Your Ref: OWPC25163
Our Ref: FG/135/19/PL
Please ask for:
Mr Z Denton

Demolition of a silo & erection of an office building (B1(a) Business), 6 No. parking spaces for office workers & erection of boundary fencing.
Silo at Former McIntyre Nursery Littlehampton Road Ferring

Thank you for your internet comments made on 3rd December 2019 which has been recorded as **'an objection'** with the comments as follows:

TITLE: Proposed Plans & Elevations

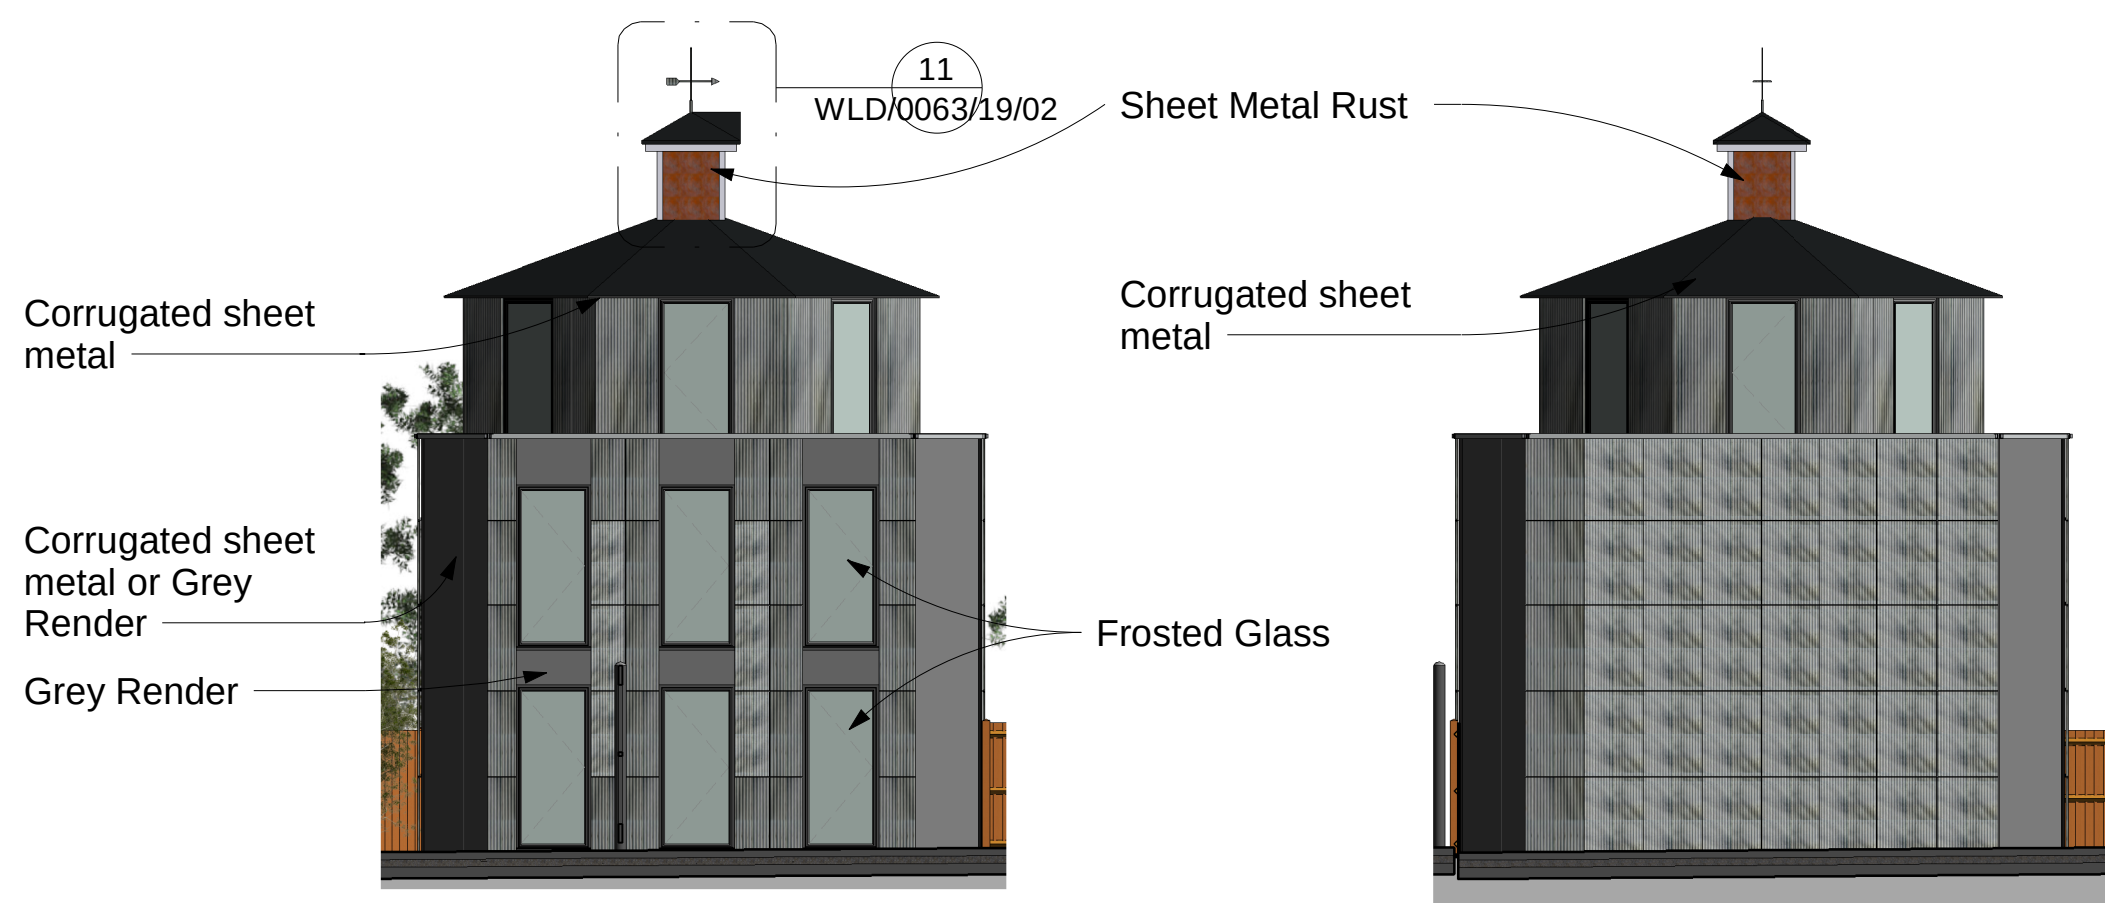
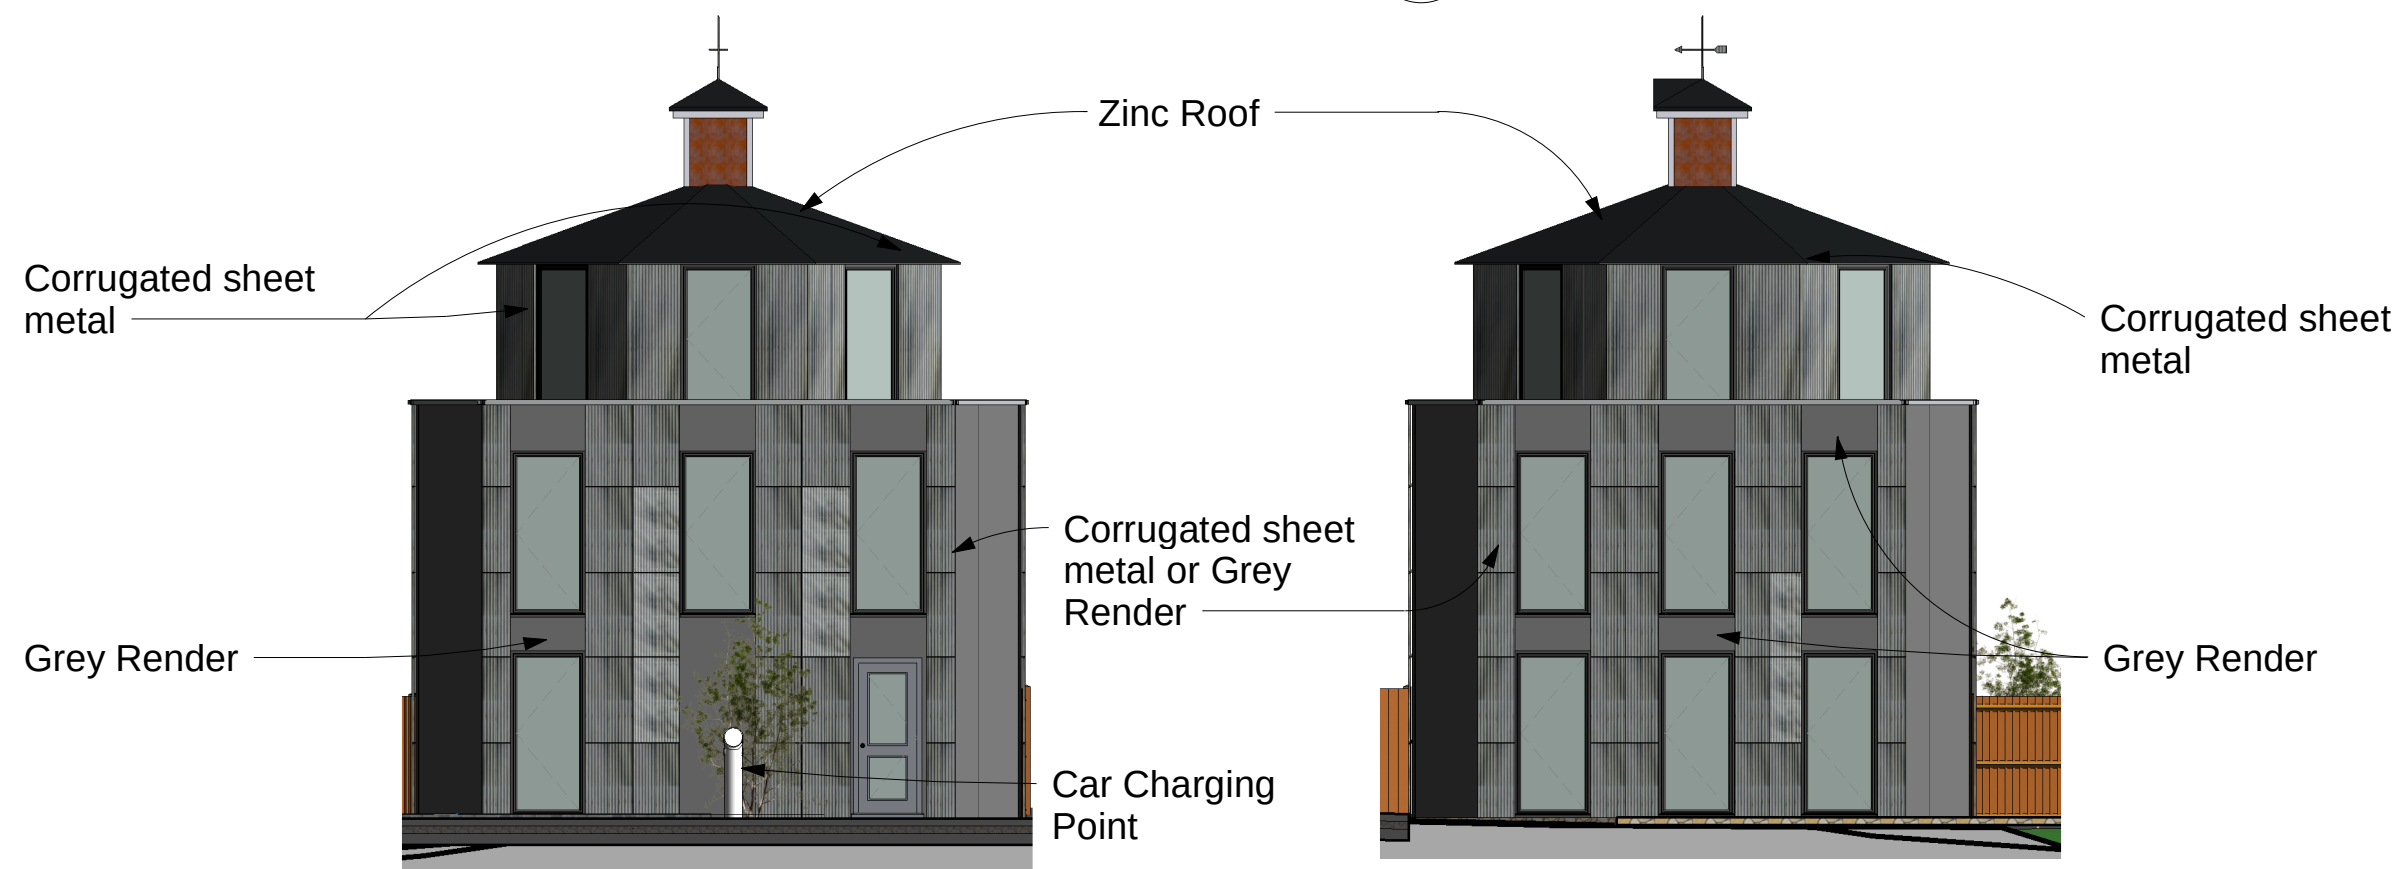
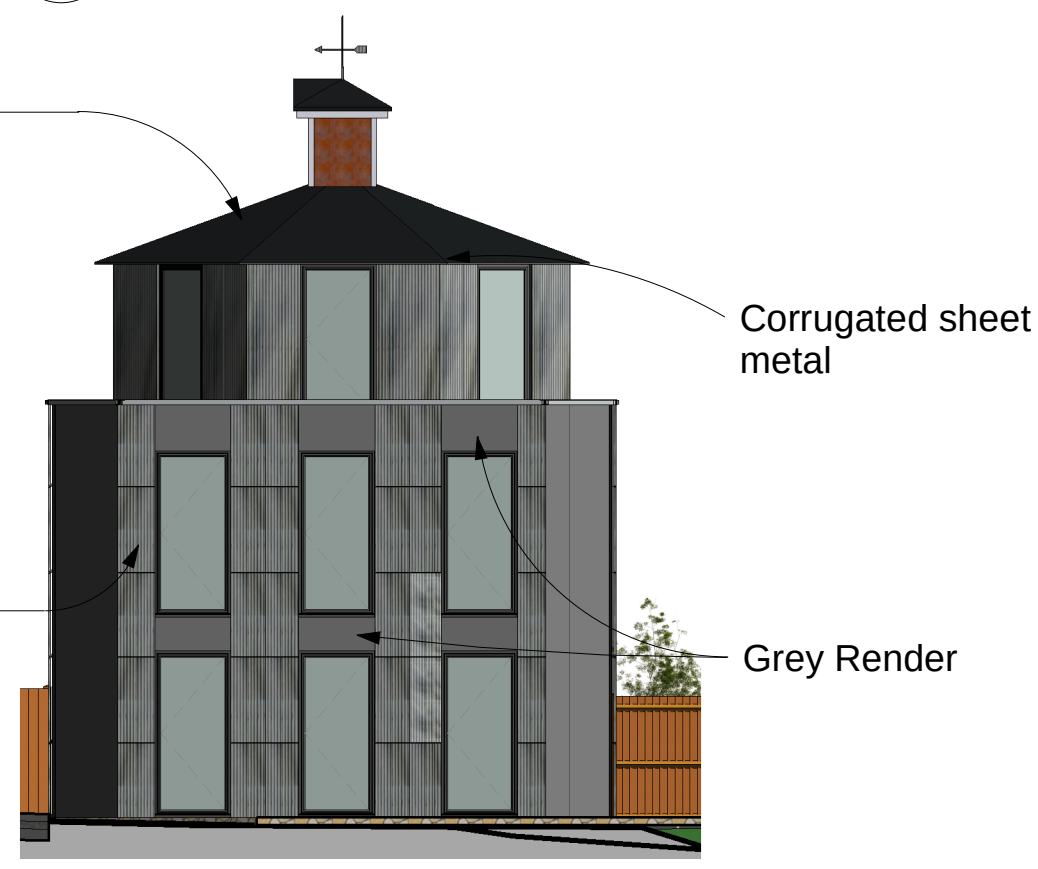
The current proposal, while making some effort to reflect the design of a silo, has a significantly greater footprint and is higher than the original structure. This would stand out as a dominant feature of the landscape in direct line of site of Highdown Hill and the South Downs National Park, contrary to the Local Development Plan. We urge Arun District Council to resist such moves to achieve change of use on invalid grounds and support the Local Development Plan to protect the rural, agricultural landscape of this unique area from further unwarranted and inappropriate development.
